Mid-Valley Drainage Management Plan

VOLUME 5 – Appendix 3

APPENDIX 3 AHYMO_97 AND SWMM PROGRAMS SENSITIVITY ANALYSES REPORT

RE: Mid Valley Drainage Management Plan

Figure 14. *Depth-Area curves.*

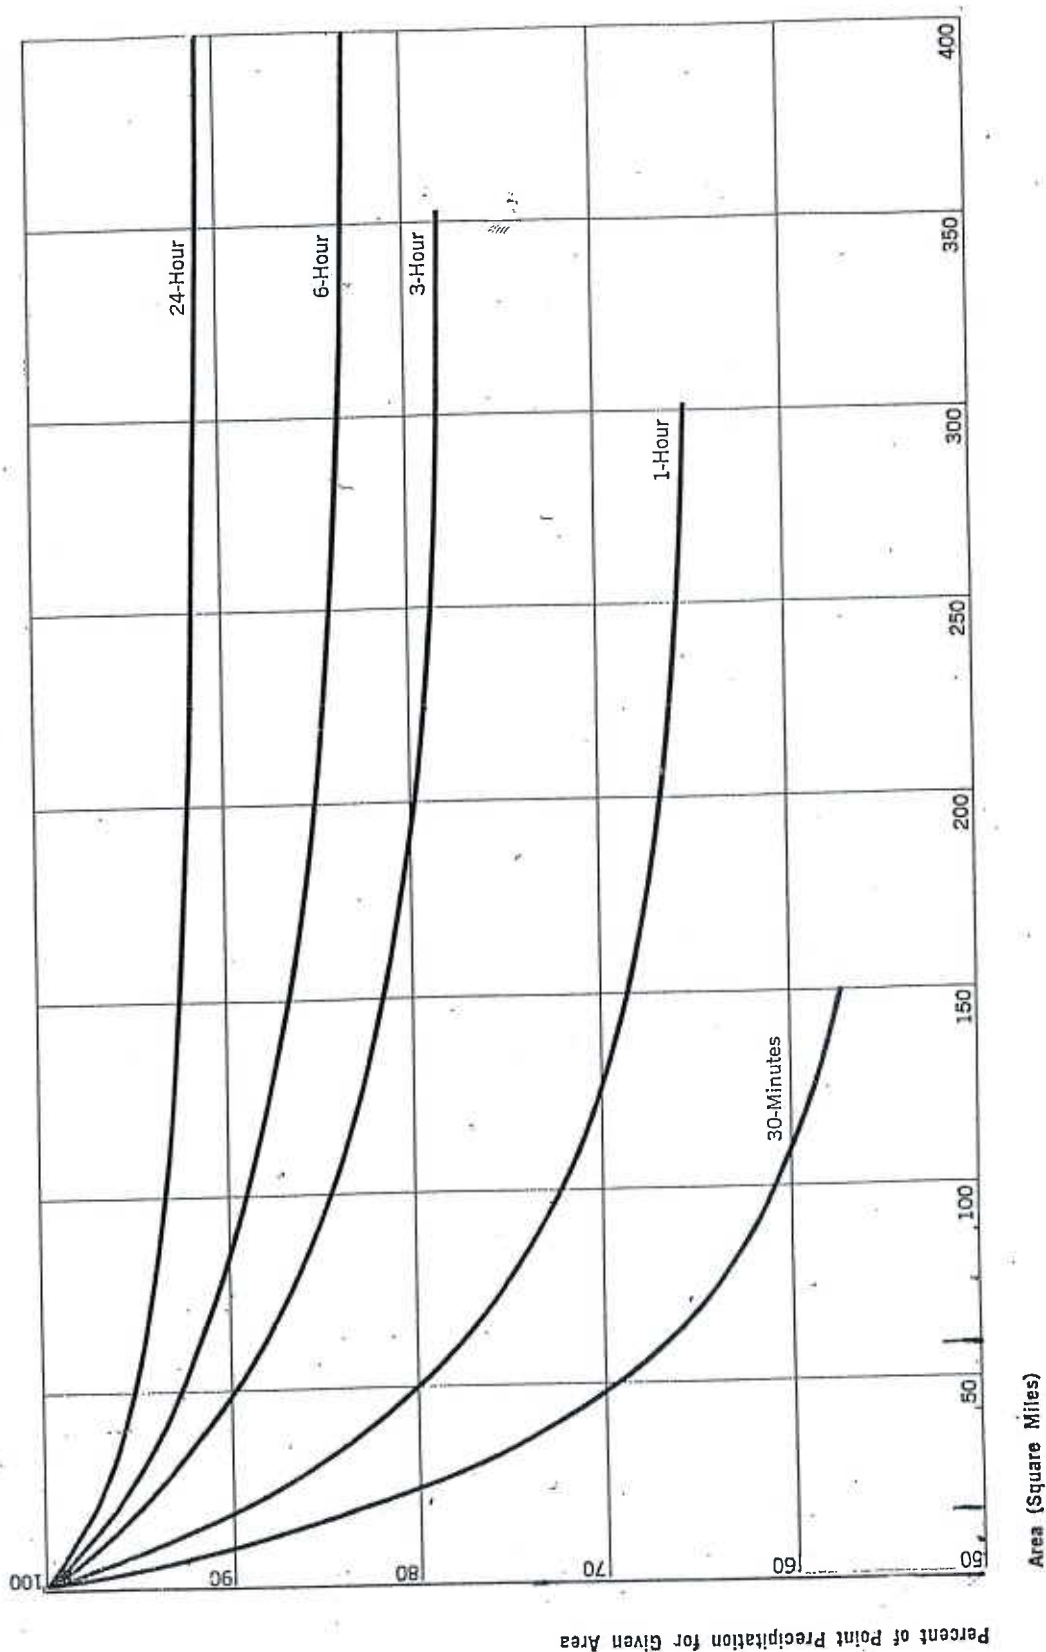
- I could not find the Depth-Area curves and Figure.B-2 in Appendix 1 as indicated on page 1.

I apologize for this omission, I will provide this to you. Our total area is probably about 5 square miles and if major subgroups are considered independently, each would be say 2 square miles, therefore areal reduction factors, as you will see really do not apply.
